Your Ref: OWPC6556
Our Ref: FP/133/15/HH 22-06-2015
Please ask for:
Mr D Vick

Loft conversion & rear extension. Amendments to approved application FP/198/14HH
4 The Midway Felpham

Thank you for your internet representation made on 12th August 2015 which has been recorded as '**an objection**' with the comments as follows:

Proposed Elevations

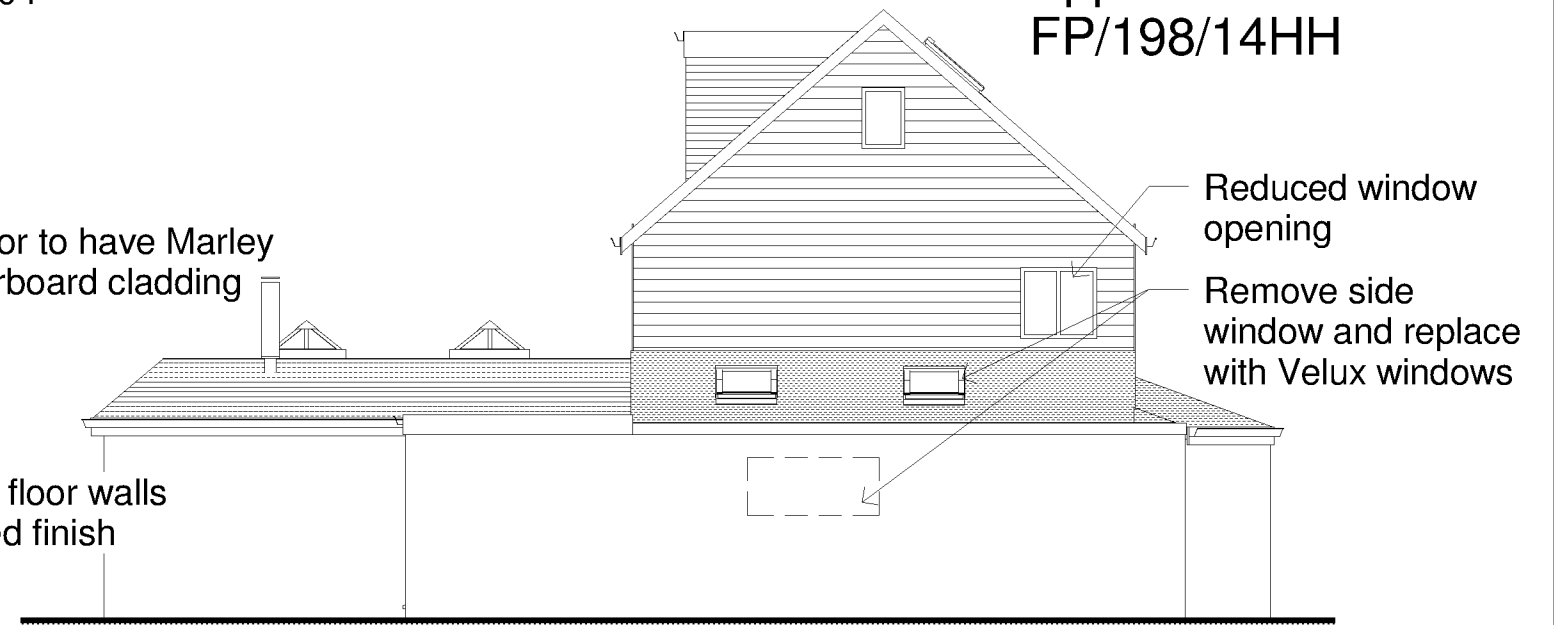
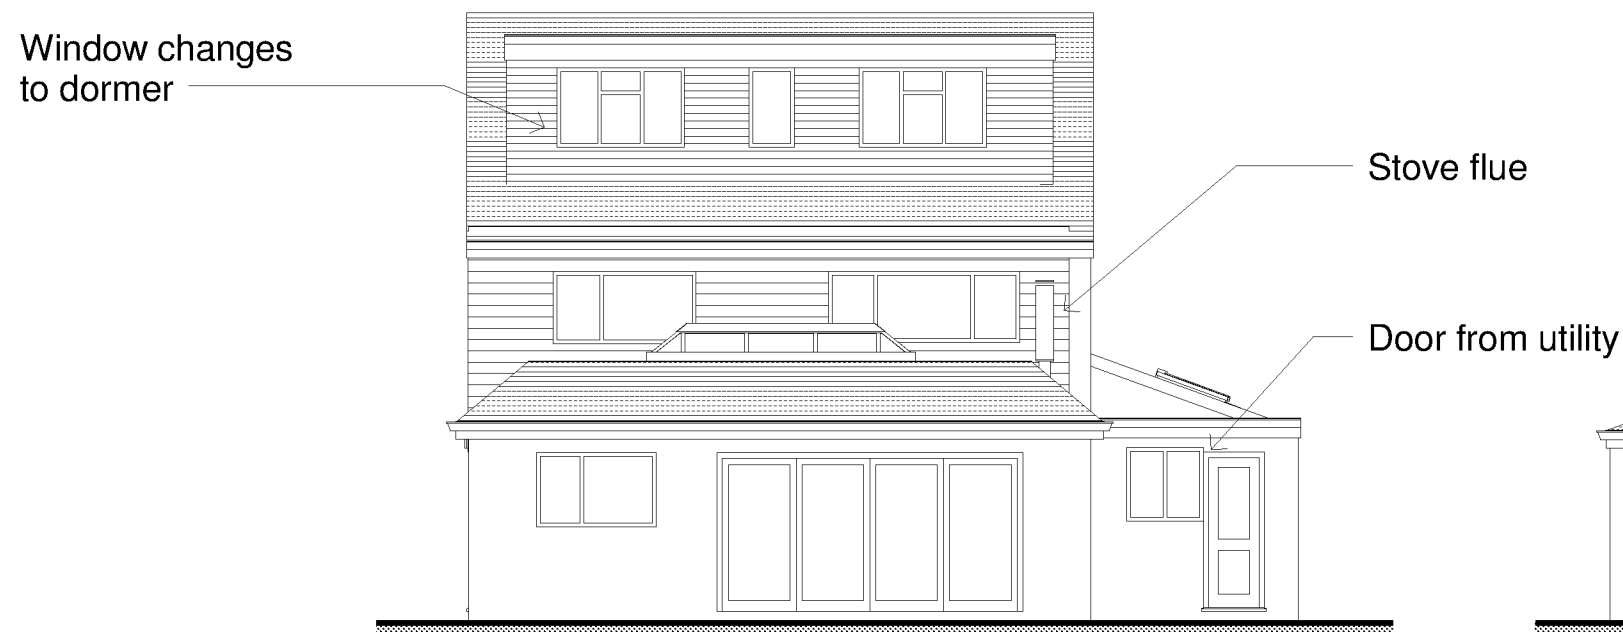
The new wall would be higher than the existing fence, it would result in the need for more frequent moss removal from the path for the elderly resident of the Chalet.

In addition flat 2 of 6 the Midway will have a darker bedroom and kitchen, if the path is made more narrow and walls higher.

Proposed Ground and First Fl

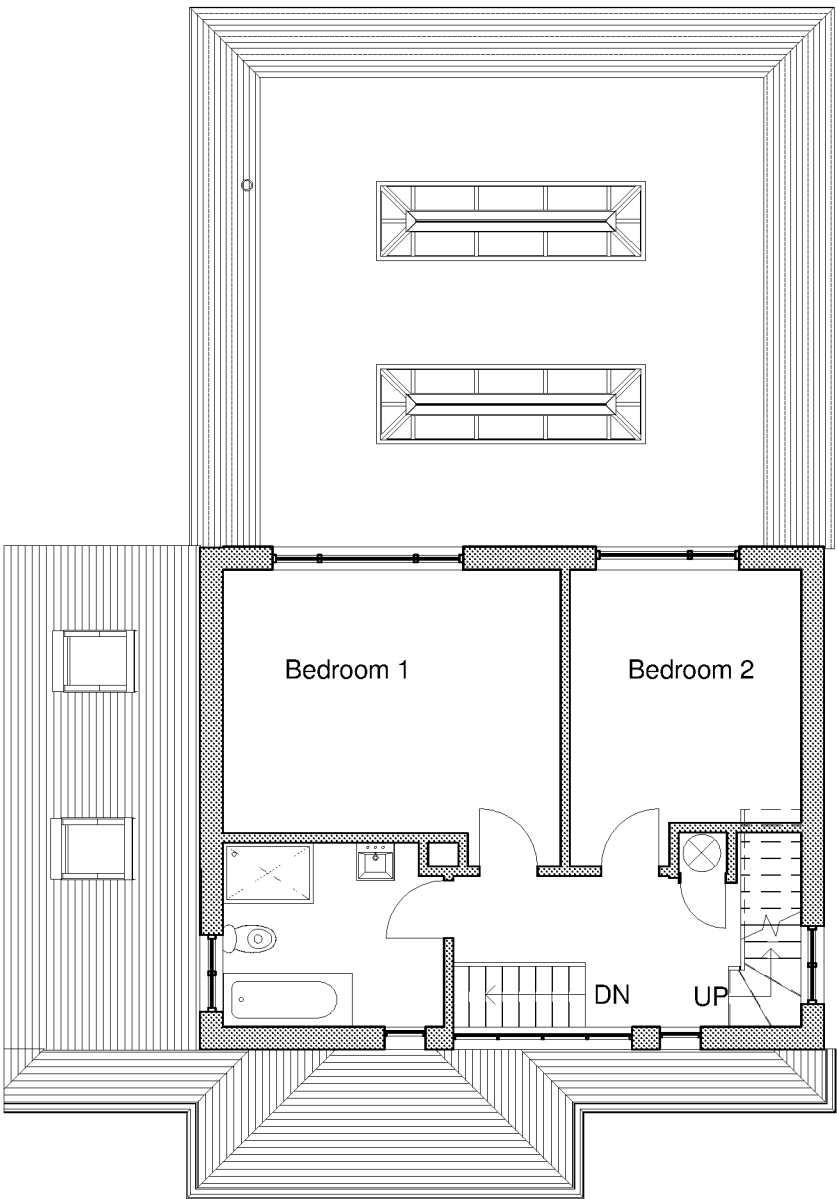
We understand that the owners of 4 the Midway intend to remove the boundary wall & fence between no 6 & 4 and rebuild a new utility on the boundary. In the process realigning to take a few inches of our already narrow access. Please note that we understand from our plans and the previous owner of no 4 that this boundary is owned by no 6. and we have maintained it accordingly.

If building is on this boundary the gutters will overhang our path to the front door of 'The Chalet' it appears a long run of roof gutter which will overflow onto the Chalet front door area if not maintained, this will necessitate access to our property, being the kitchen & bedroom windows of flat 2, on a regular basis.

In our opinion any further extension on 4 The Midway should be a meter inside their boundary to enable maintenance and drainage to be within their property.
